**Washington State
Department of Transportation**

Subject: SP-26-00007, Schultz
SR 97 MP 143.04 left, Ellensburg Ranches Rd.

We have reviewed the proposed preliminary plat and have the following comment:

**SCHULTZ SHORT PLAT
PART OF SECTIONS 26 & 35,
TOWNSHIP 19 NORTH, RANGE 17 EAST, W.M.
KITITAS COUNTY, WASHINGTON**

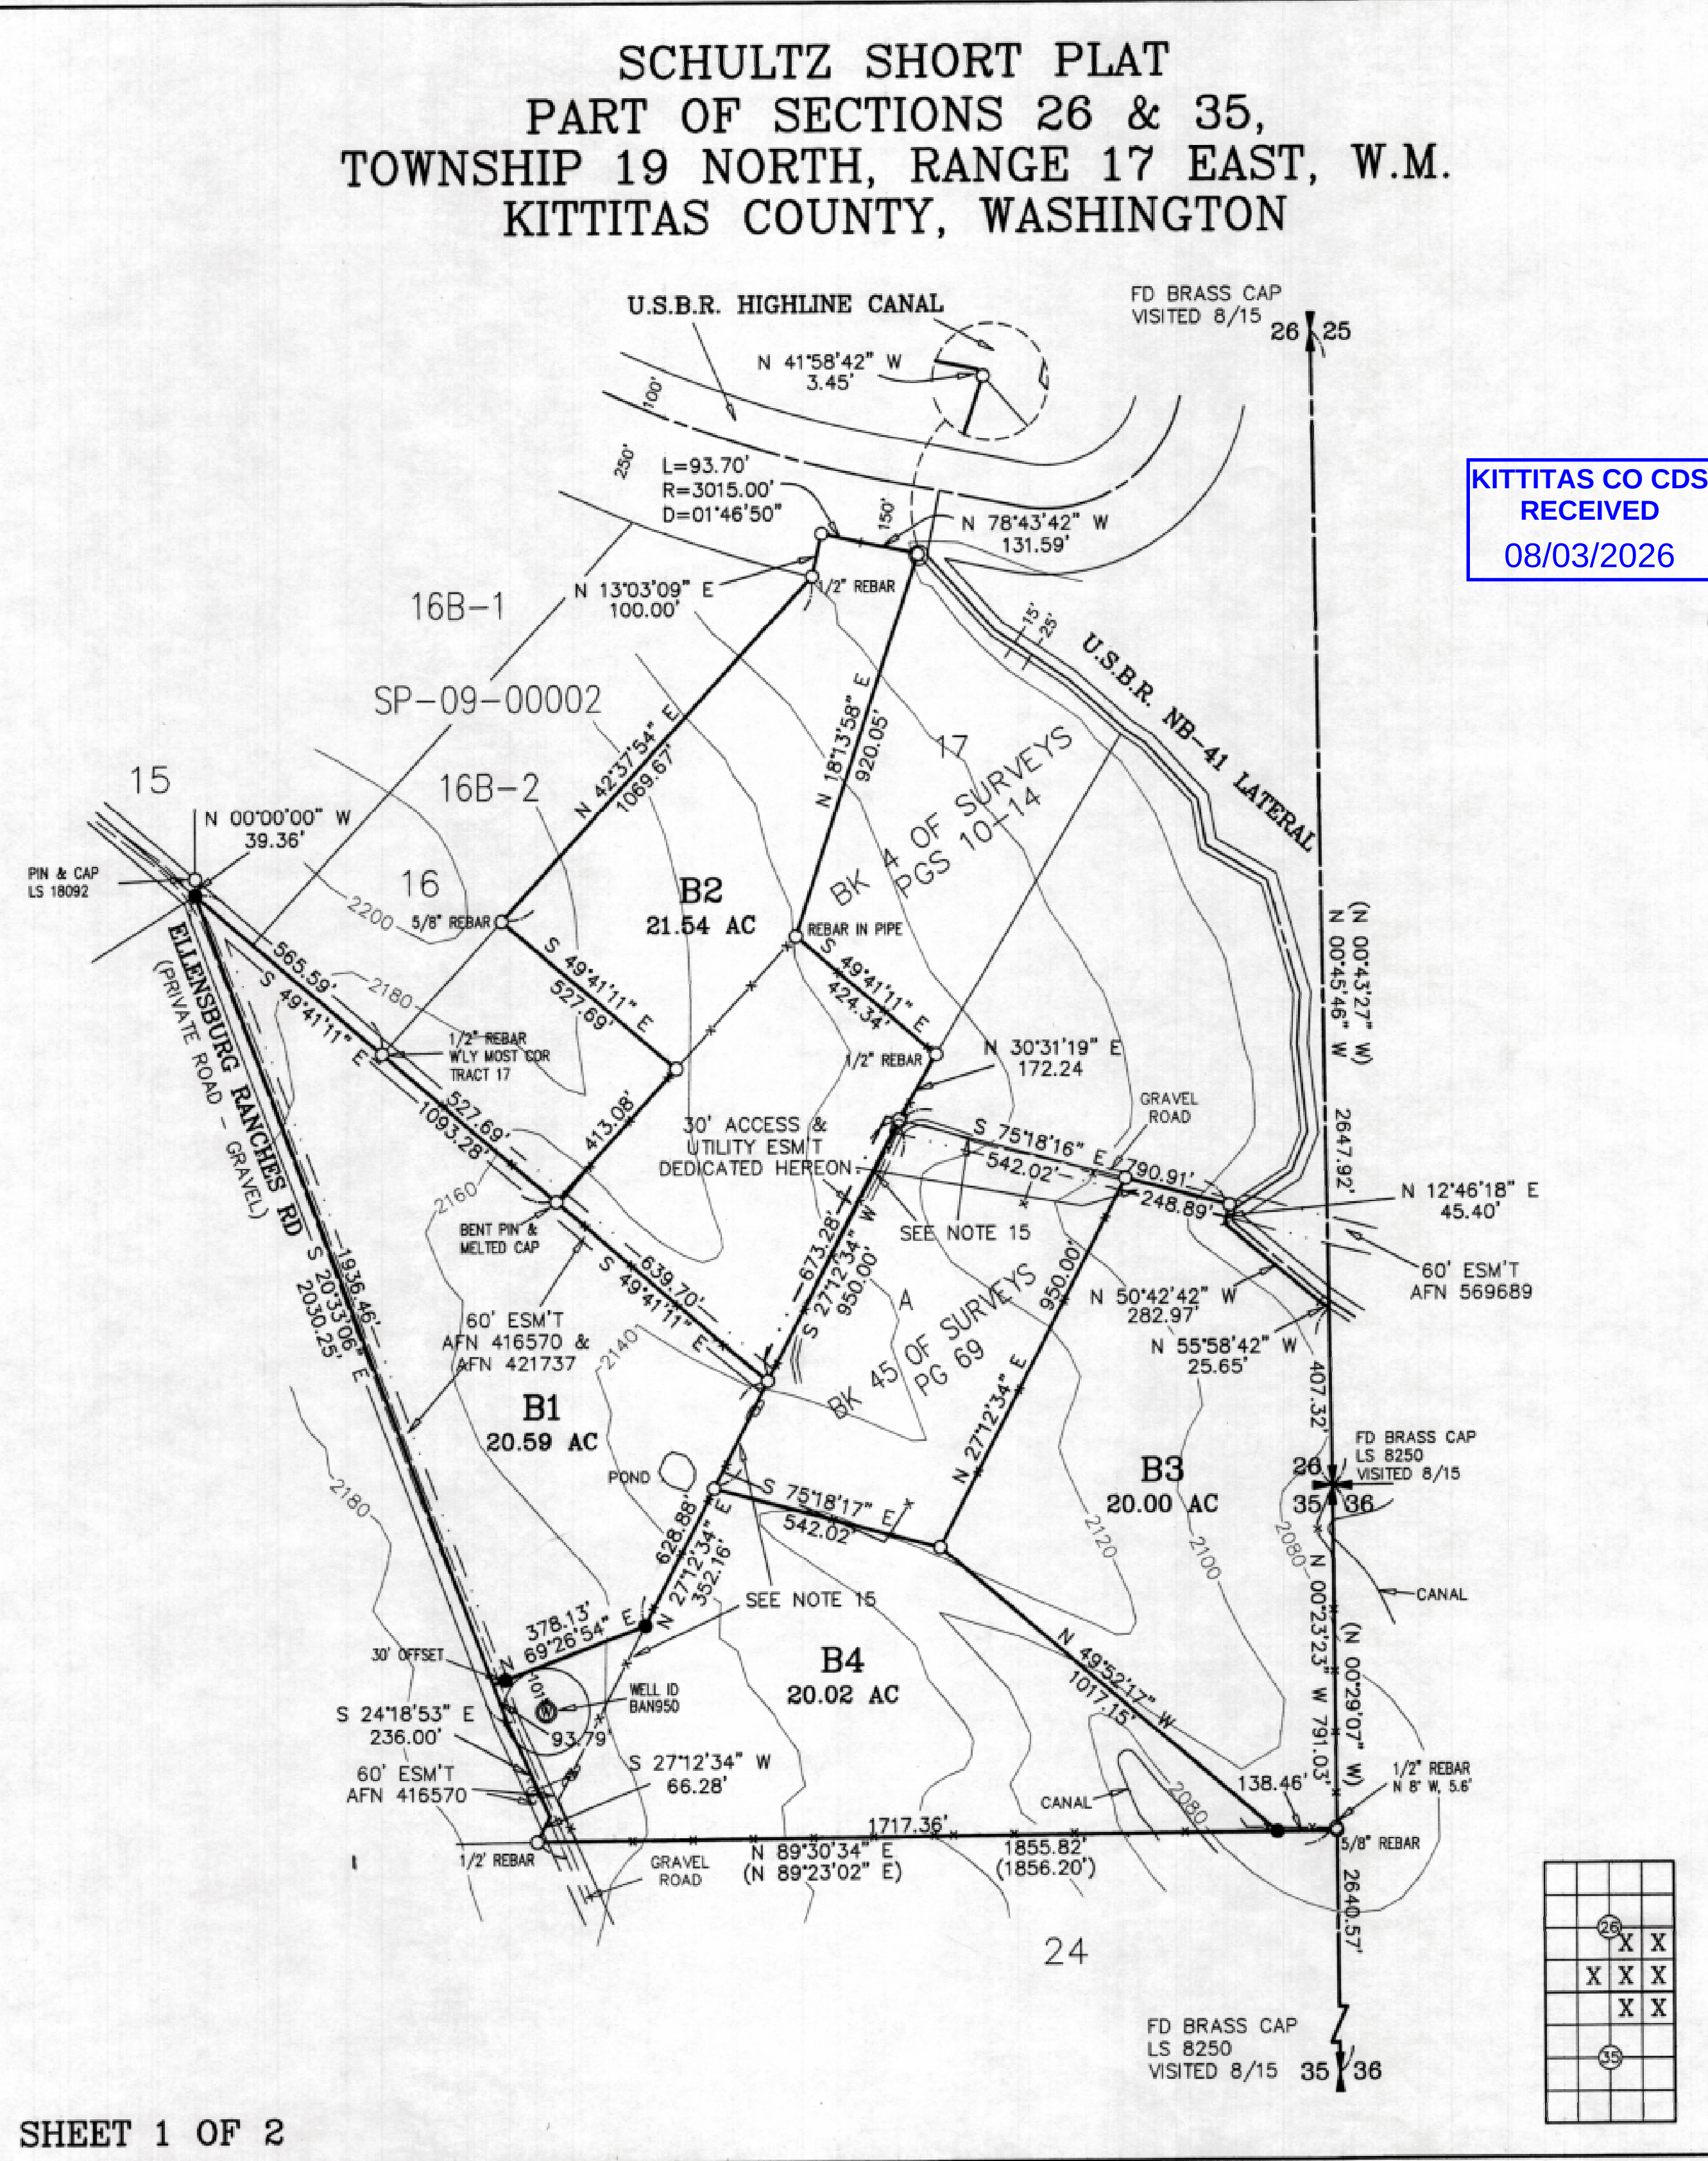
The subject property is adjacent to U.S. Highway 97 (US 97), a Class 1 managed access highway with a posted speed limit of 65 miles per hour. Currently, access to the property is via Ellensburg Ranches Rd., a permitted joint use approach at milepost 143.04 left. This approach permits the Ellensburg Ranches Owners Association access to US 97 not to exceed 30 feet in width and may continue to be used. No additional approaches to US 97 will be allowed.
